Please ask for: Ms Iqraa Malik
Email: iqraa.malik@terraquest.co.uk
Telephone: 01212341390
Our Ref: FG/166/20/HH
Your Ref:
Date: 17th December 2020

Application for Planning Permission for Works or Extension to a Dwelling

Development: Creation of 2 habitable rooms in existing garage and remodelling of GF bedroom to accessible bathroom to accommodate dependent family member. Extension and remodelling of existing rear conservatory to accommodate kitchen and store room. Erection of timber clad storage container/ outhouse on front drive.

Location: 5 Ferringham Way Ferring BN12 5NG

Project
Elevations: Container Storage, sheet 1

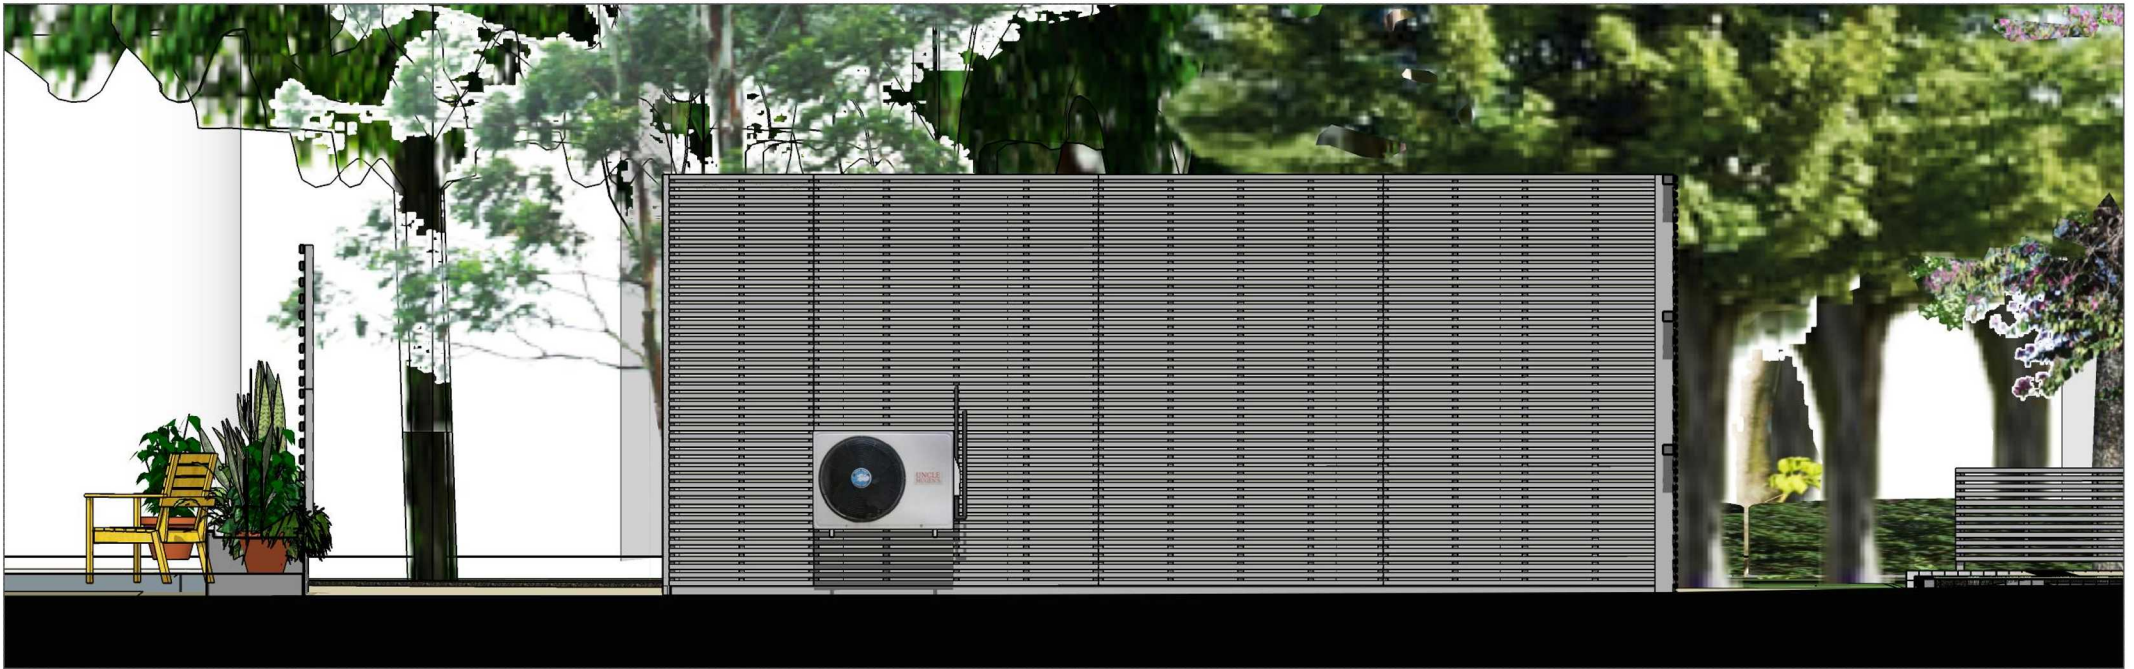
Elevations: You are required to provide all elevations of the outbuilding.

Project
Site Plan, Proposed

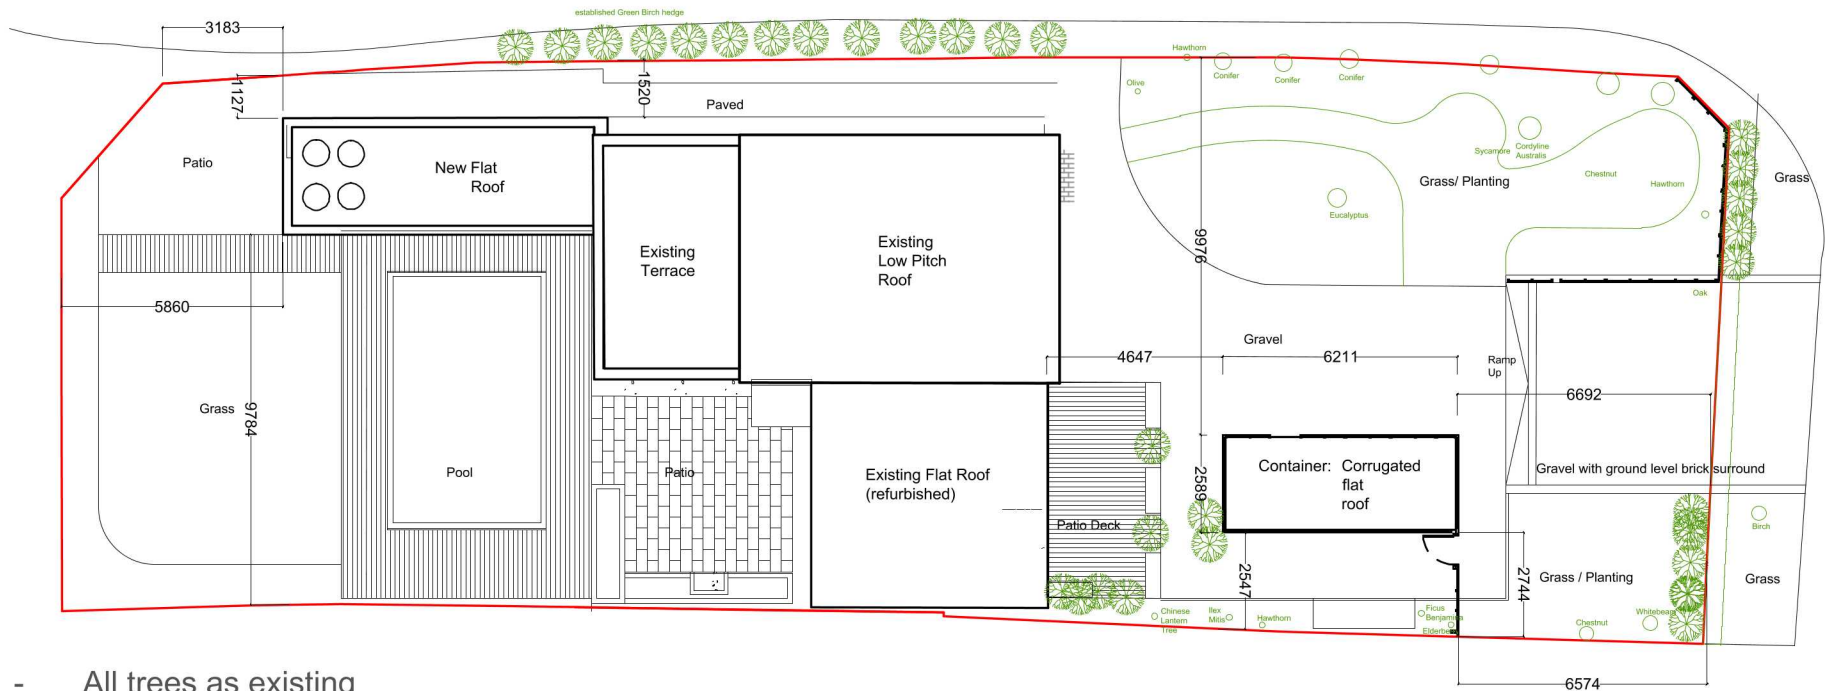
You are required to include dimensions from the proposed extensions and alterations to all site boundaries.
